Re: Status of Improvement Permit Application #4-5-10799

On November 29, 2004 an Environmental Health Specialist from the Harnett County Health Department attempted to evaluate your property for the purpose of issuing an Improvement Permit. This individual was unable to evaluate your property for one or more of the following reasons.

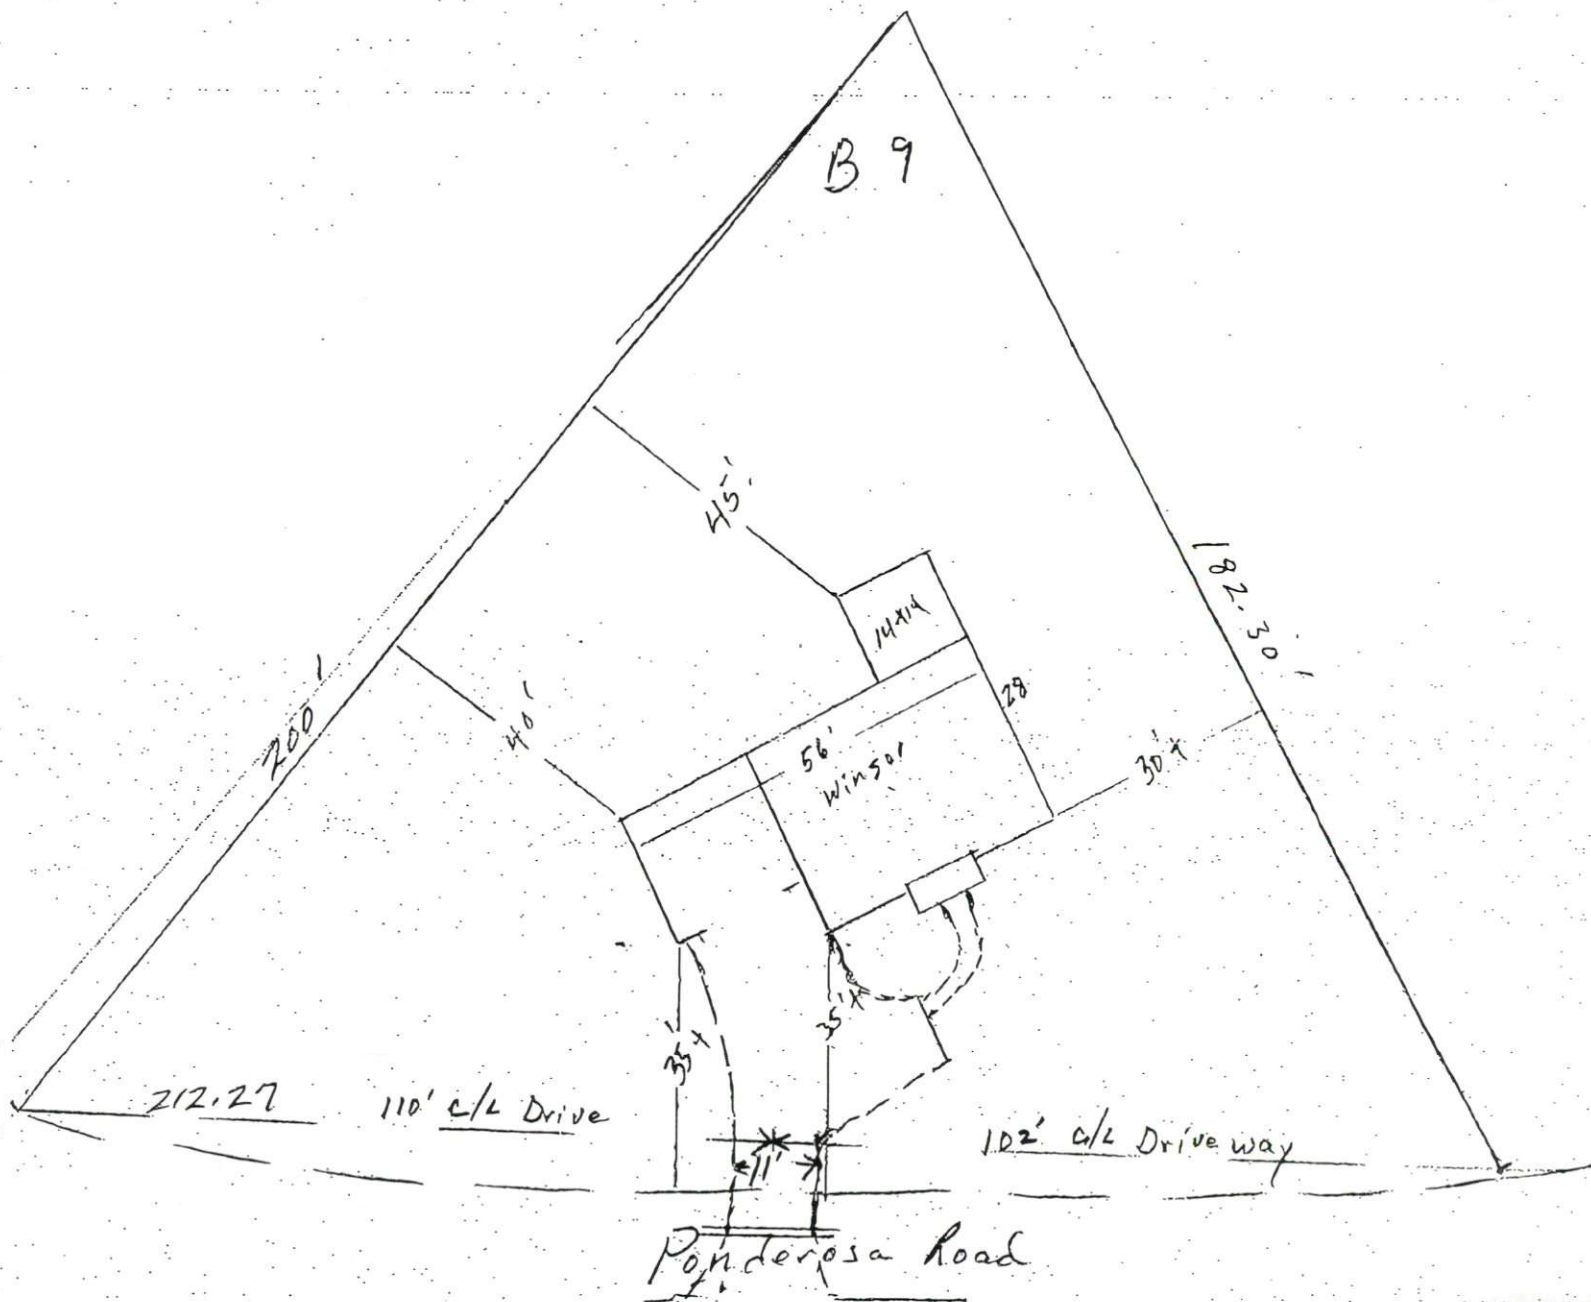
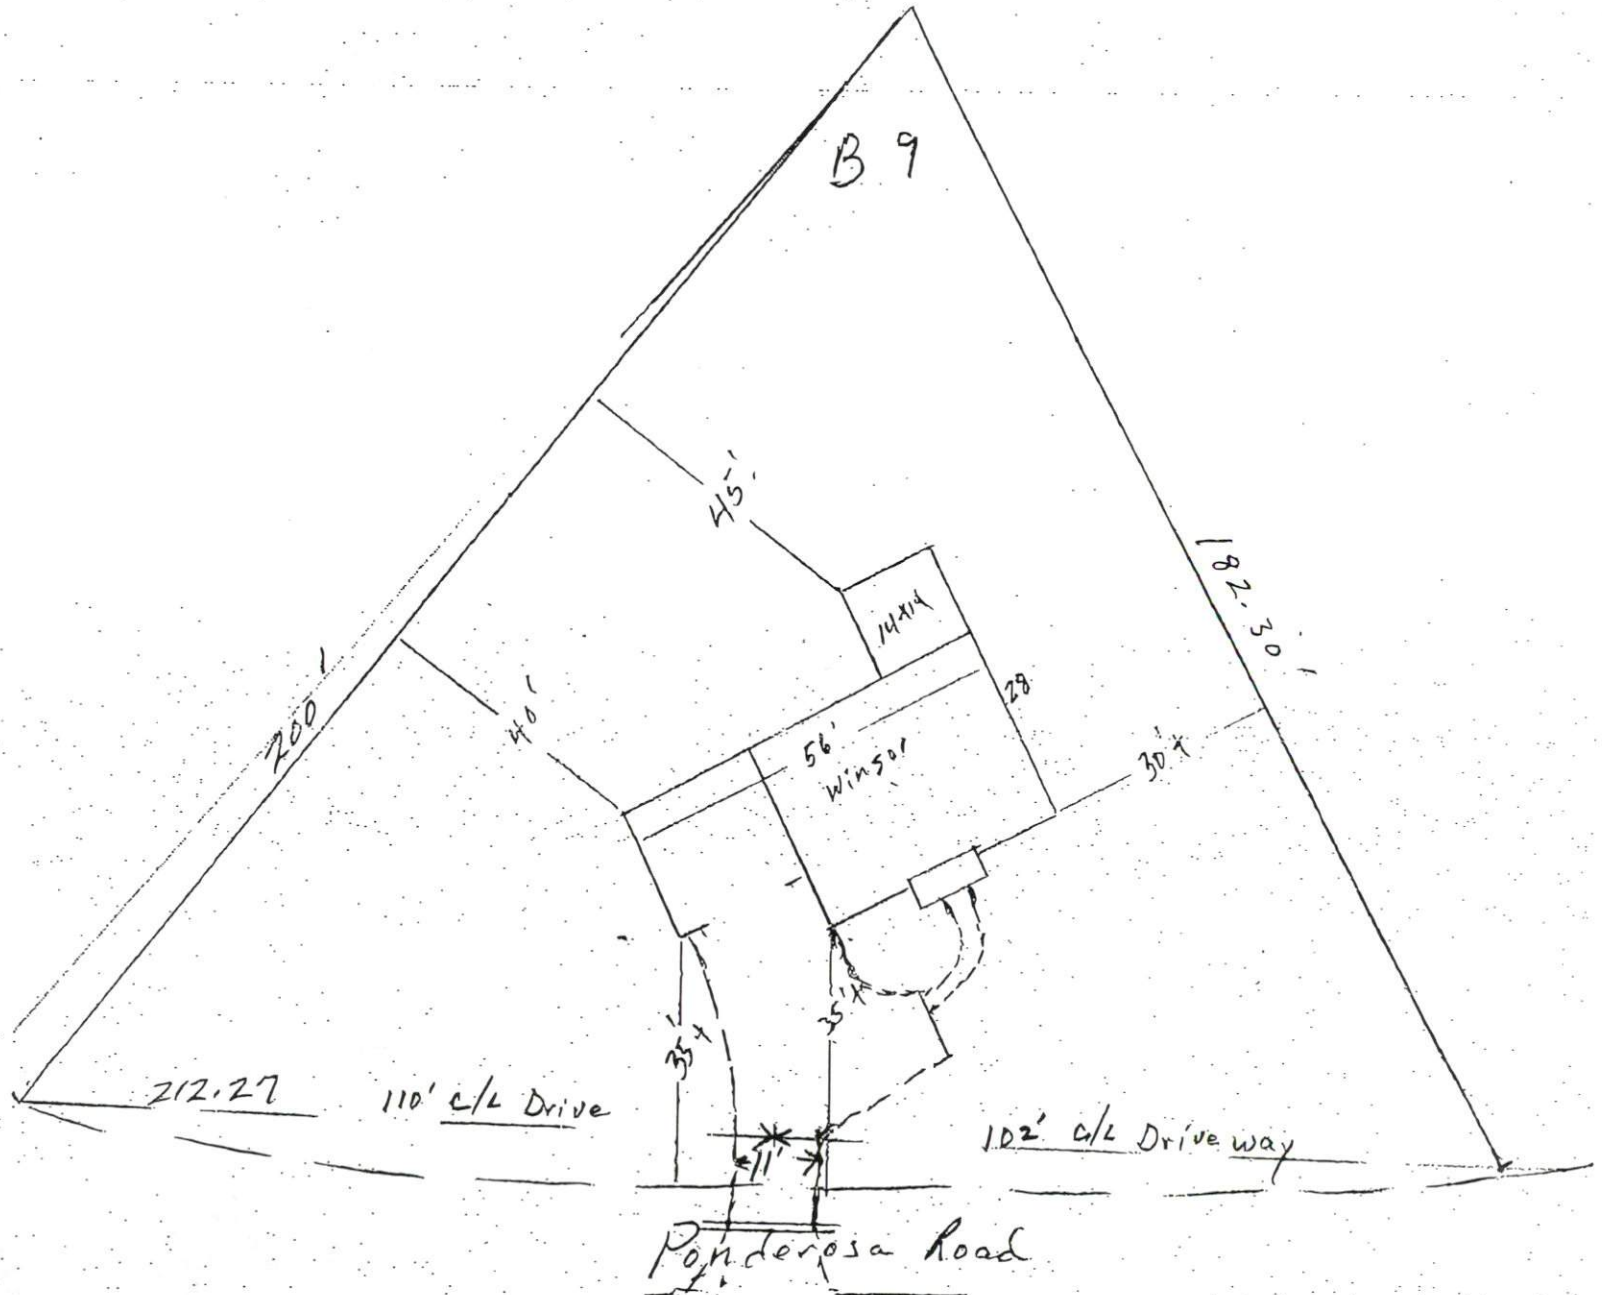
- 1. Property lines/corners not marked or labeled
- 2. House corners not marked or labeled
- 3. Directions not clear to property
- 4. Property needs brush or vegetation removed
- 5. Backhoe pits required
- 6. Other Need better plot plan

Called 12-9-04
Told Van Sr.
That Revision was
Needed - change to
3 BR.
